Consultation Response from KC,
Lead Local Flood Authority

2025/92327 Land adjacent to, 185, Woodhead Road, Holmbridge, HD9 2NW

Erection of 4 dwellings (within a Conservation Area)

Date Responded: 19th June 2026

Drawing	Scale @ A1
Flood Escape Plan	1:200, 1:100
Drawing No. 3595 (0-) 08	Revision -

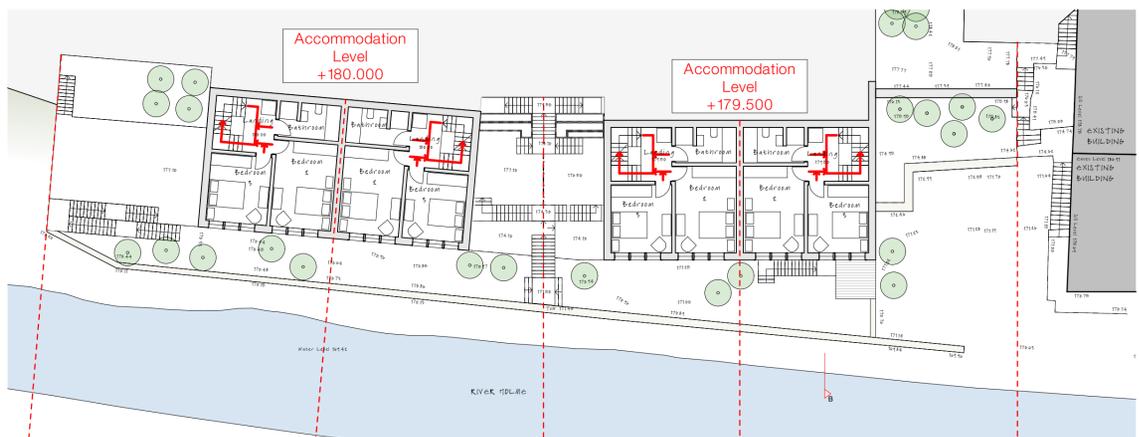
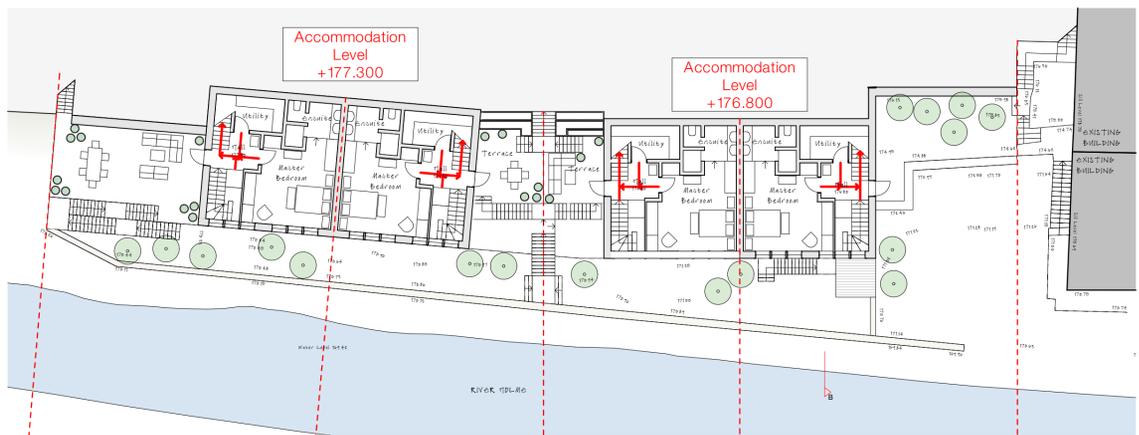
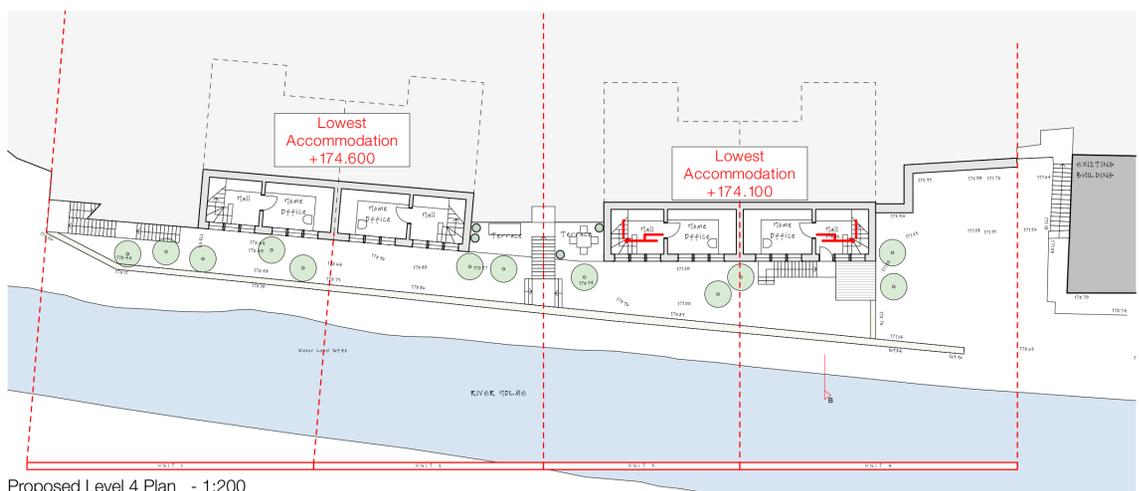
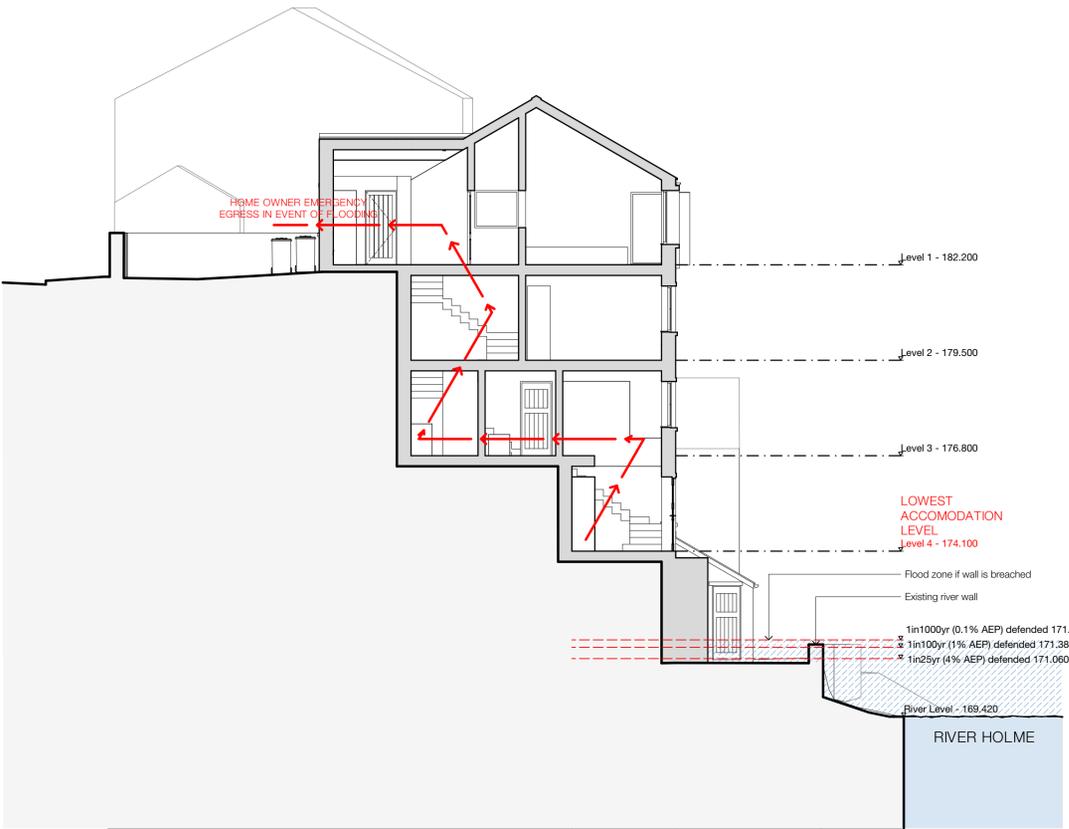
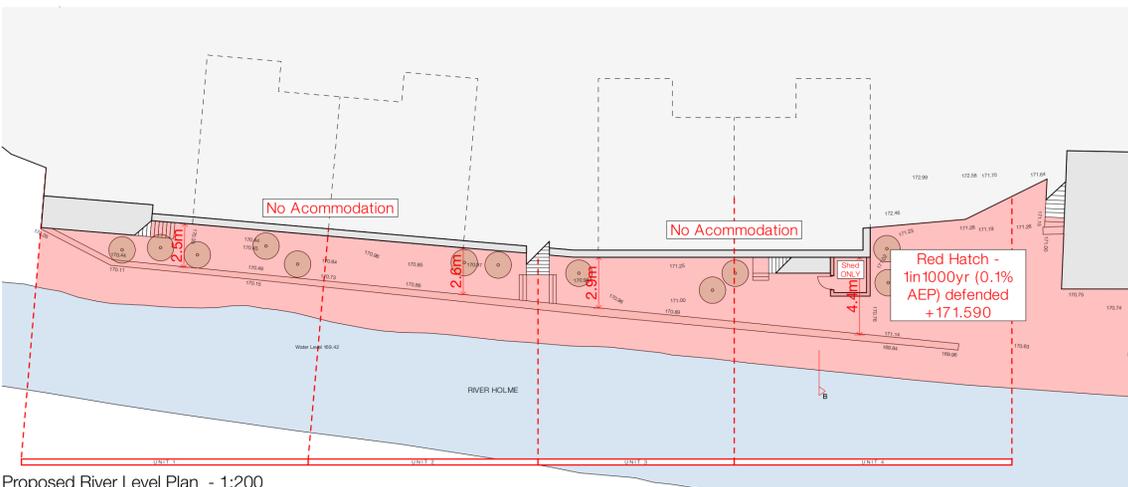
Plans should ignore and official or unofficial flood defences, i.e. walls and one of the plans appears to be reliant on a retaining wall stopping flood waters with a 1% annual chance of occurring affecting the back entrance to the properties. Flood Risk maps for planning should ignore walls and defences.
